From: [REDACTED]
Sent: 09 October 2024 11:01
To: High Grove Solar
Cc: [REDACTED]@sporle-pc.gov.uk
Subject: RE: EN0110010 - High Grove Solar - EIA Scoping Notification and Consultation

Please see below comments from Sporle Parish Council and the Sporle Neighbourhood Development Plan Group.

Drawing Title  
**Figure 2.3 General Arrangement - Central Panel Area**

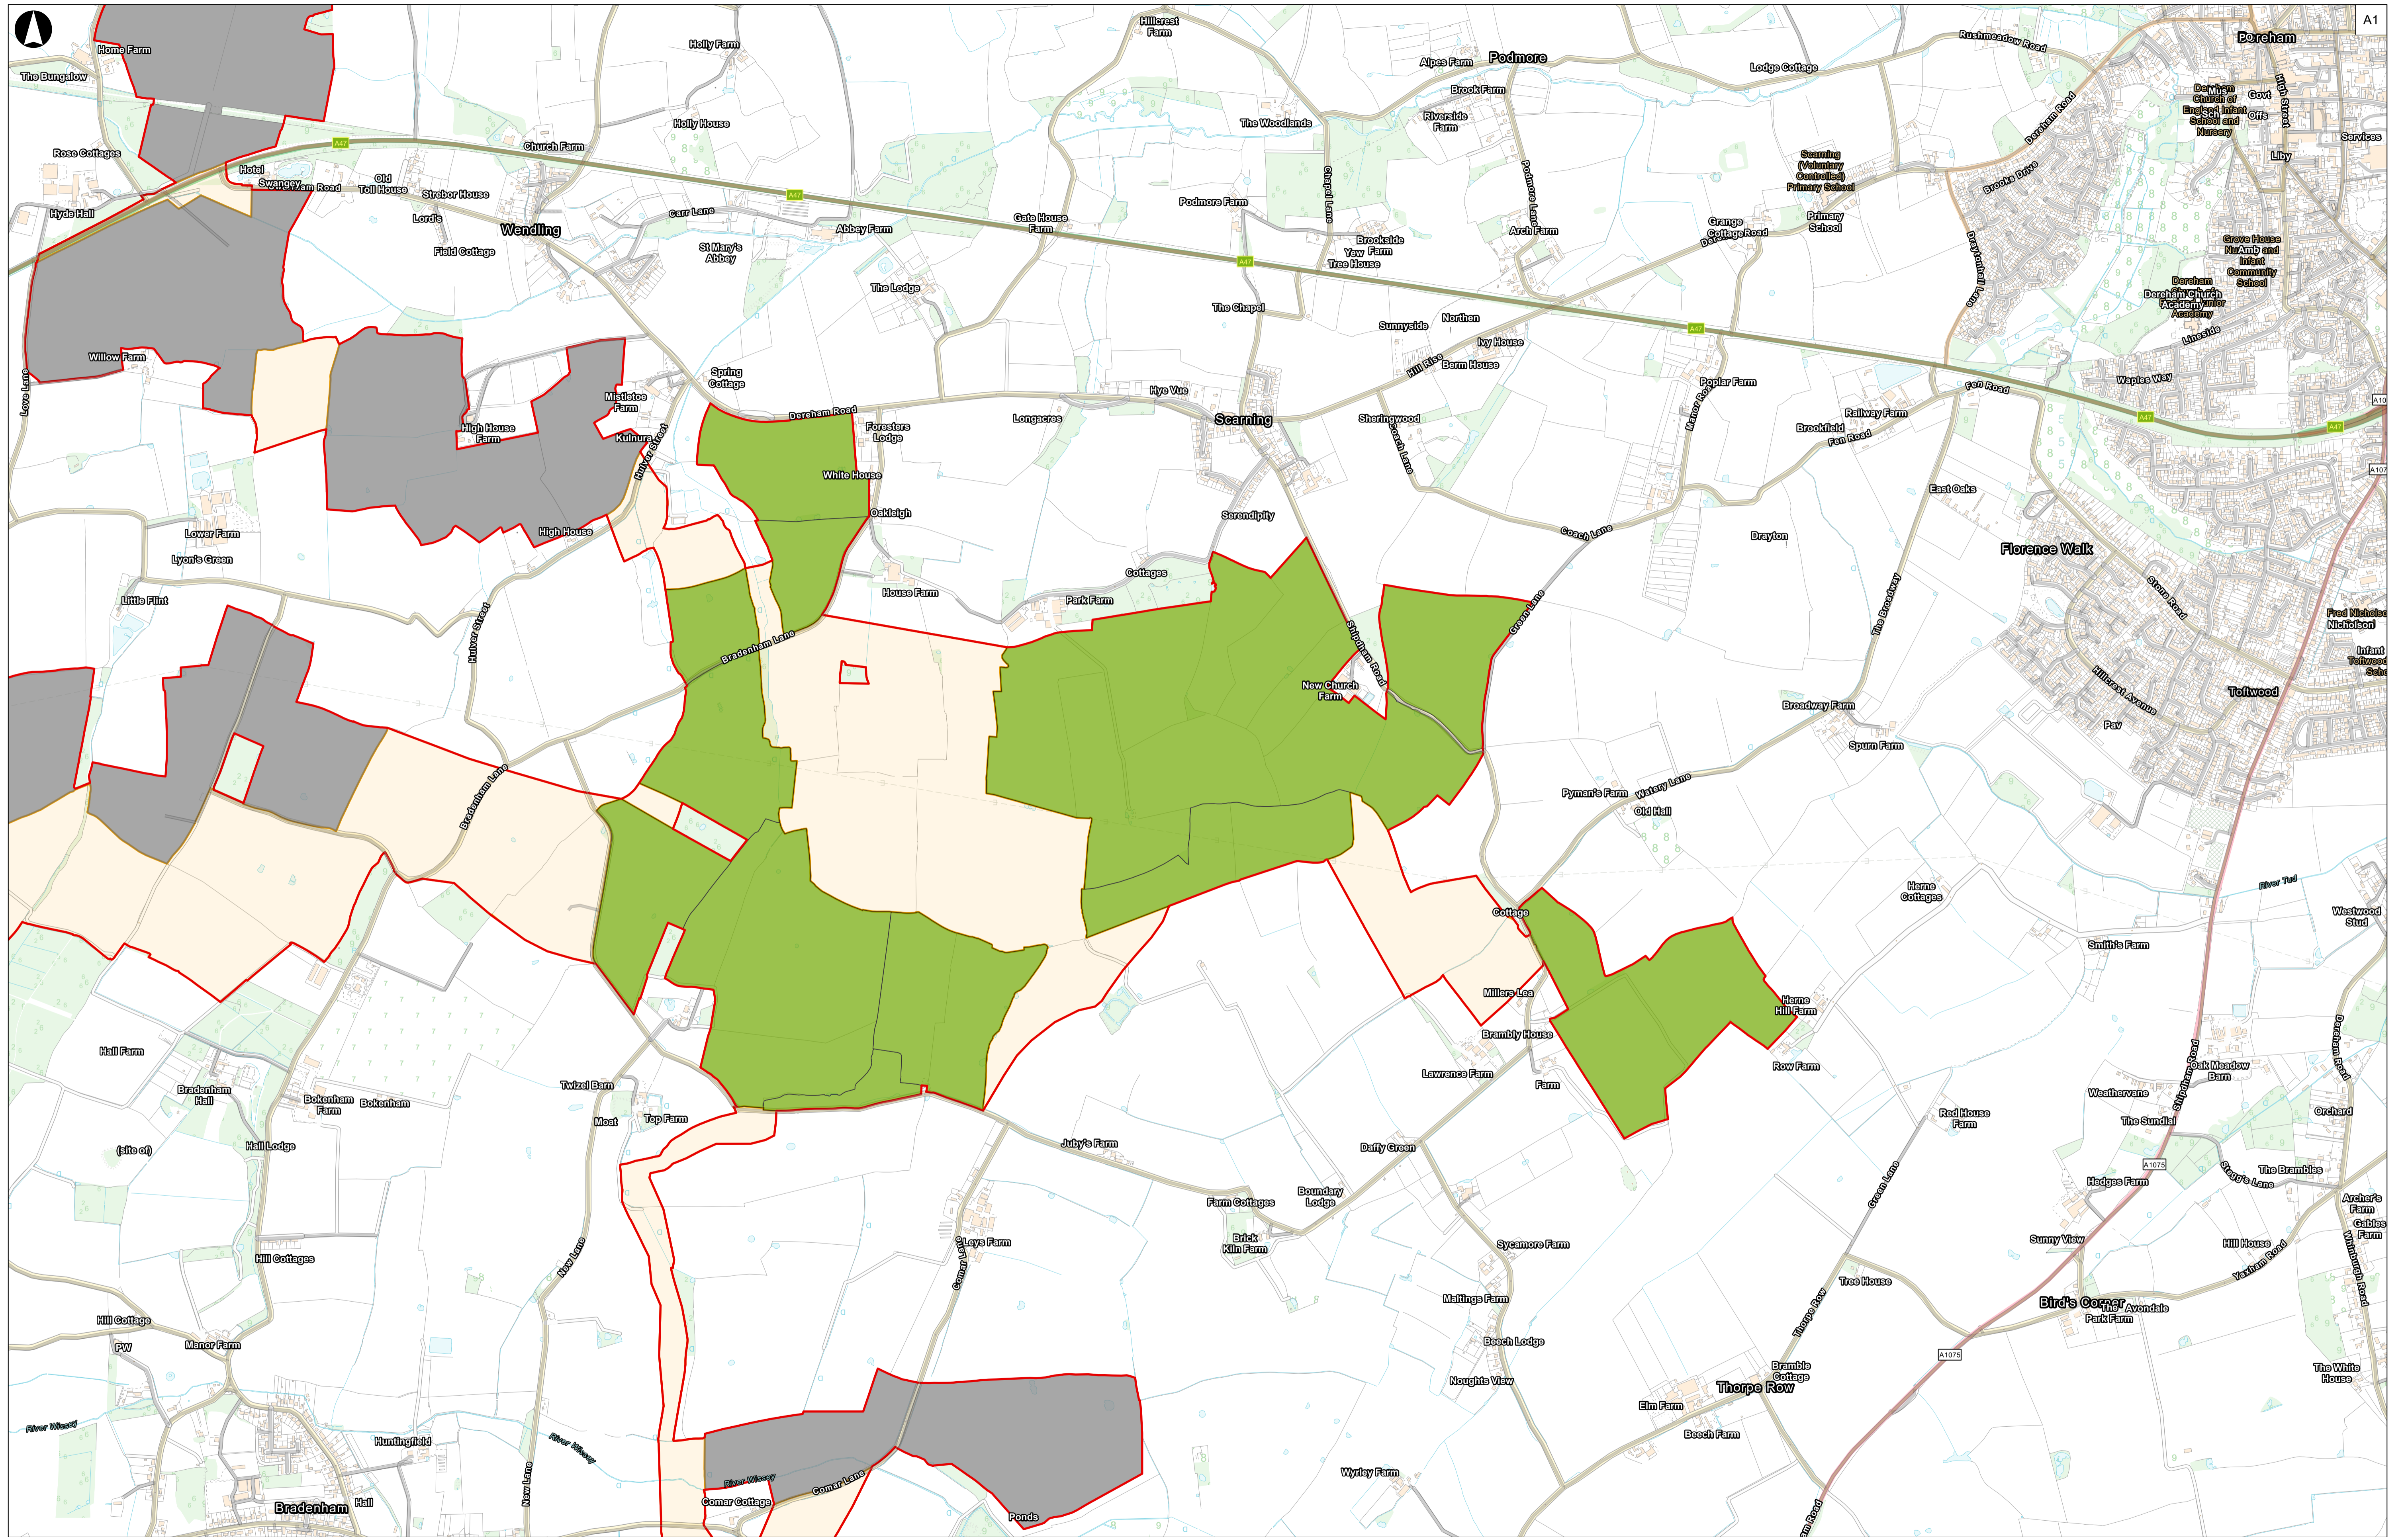
There is concern over the solar panel development surrounding Sporle, mainly the Central panel areas designated either side of the village and their closeness to the village, the visual impact on local people, the impact of increased traffic during construction and the loss of good agricultural land. The separate points of concern which the Council would like to be addressed are set out below.

2. The Council would like to ensure that the small 132kV substation and battery sites that serve the Central panel areas are kept away from the village. Although the scoping allows for assessing the possible noise and the unsightliness of an 8m high installation with 15m high communications tower, the Council wants to ensure this is carried out and part of the consultation with local residents.

Drawing Title
Figure 14.6 Zone of Theoretical Visibility (screening), and proposed Representative Viewpoints

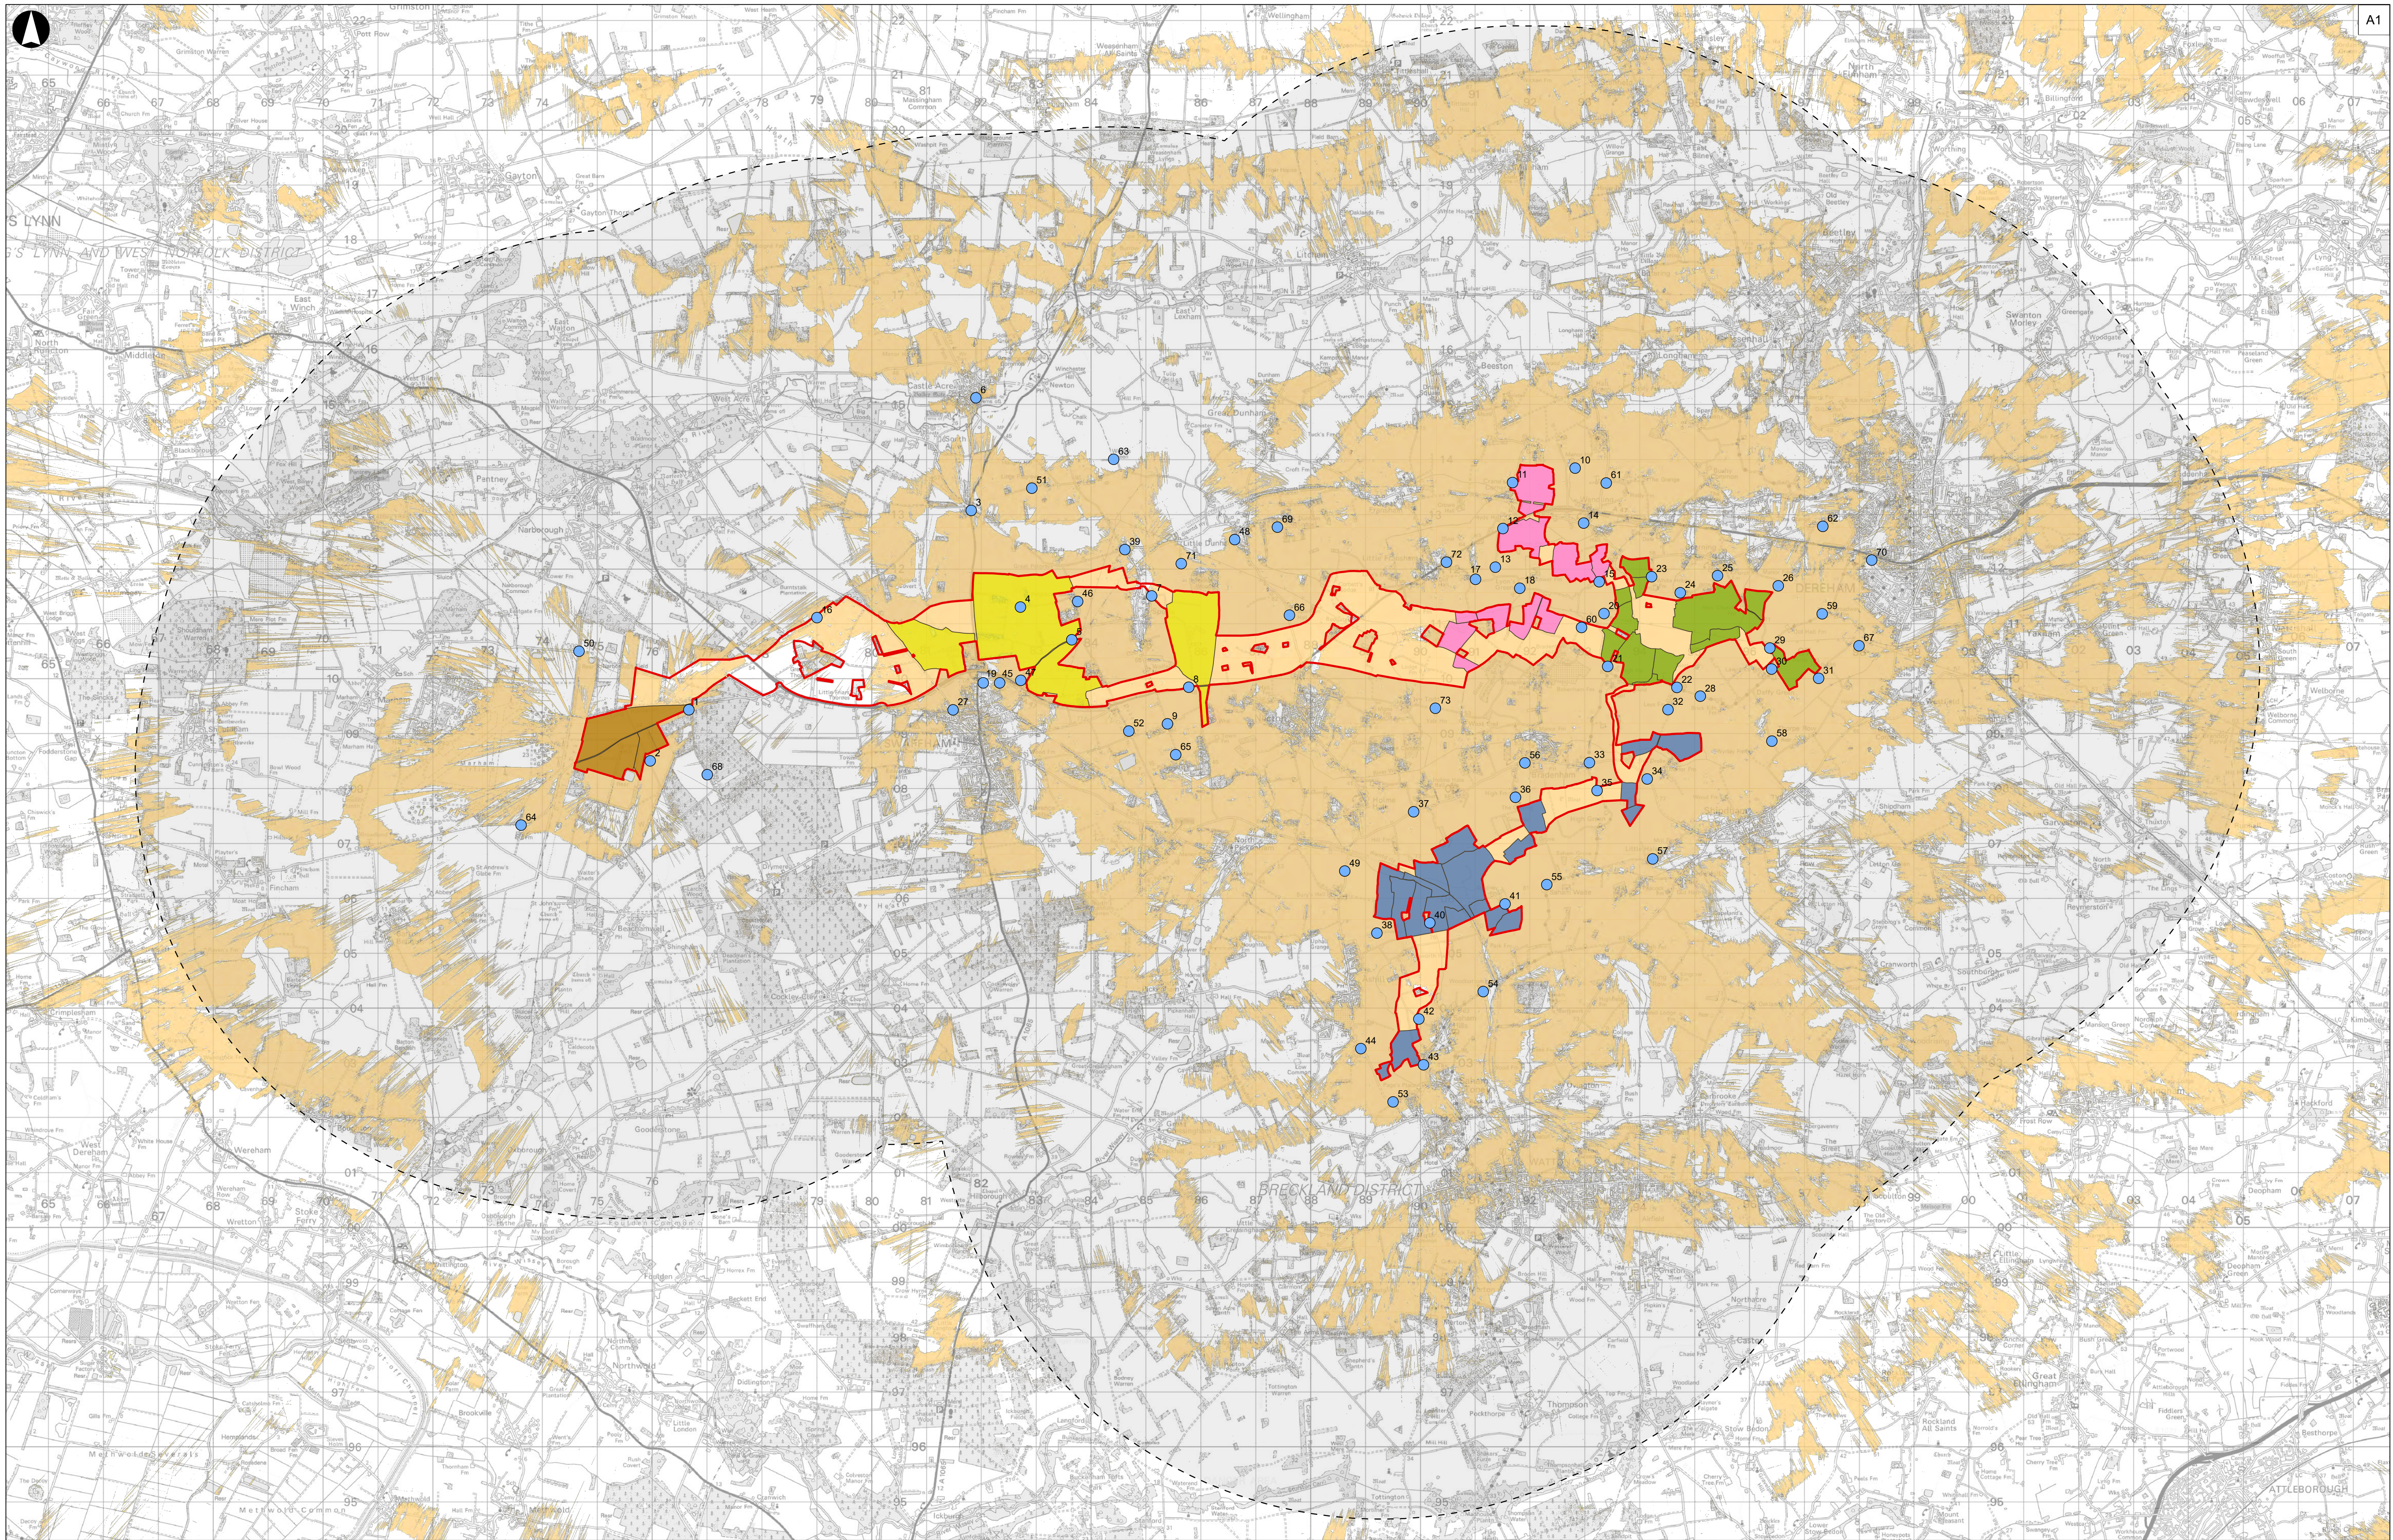
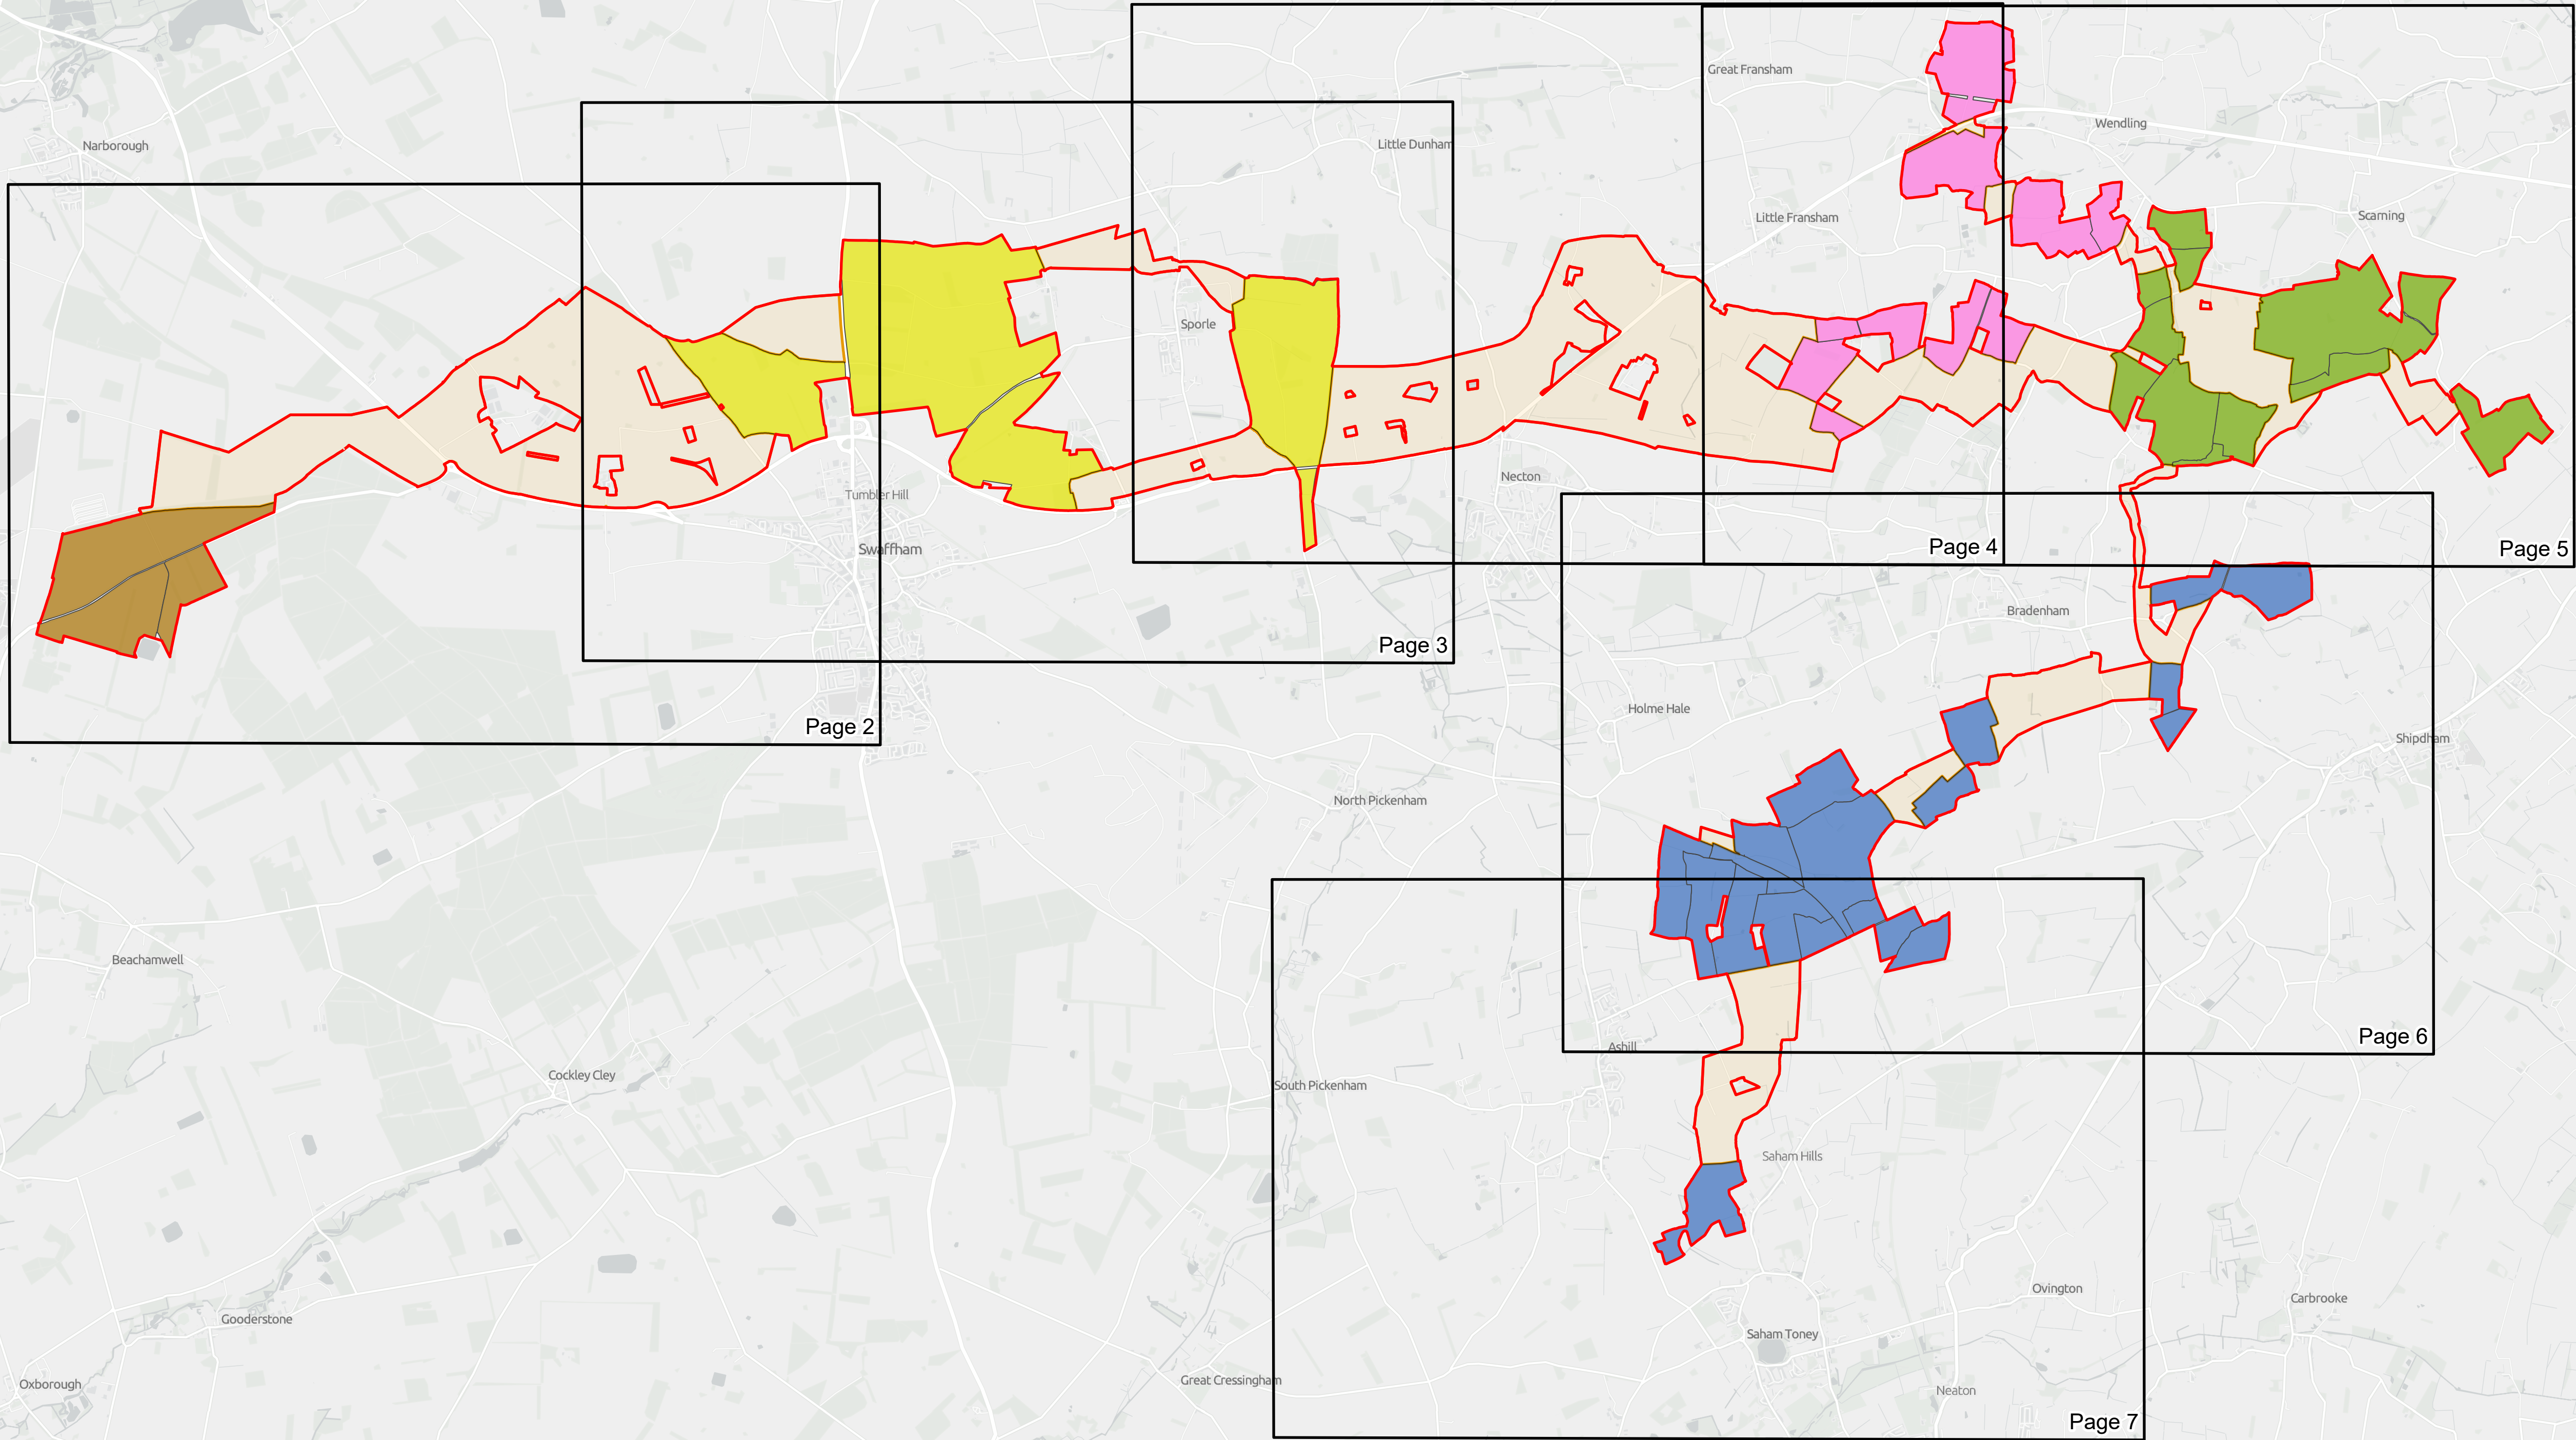
However, they list some figures in the report of work they have already done showing Zones of Theoretical Visibility (figures 14). These were not included on the documents available to be downloaded from the Planning Inspectorate, can these be made available?
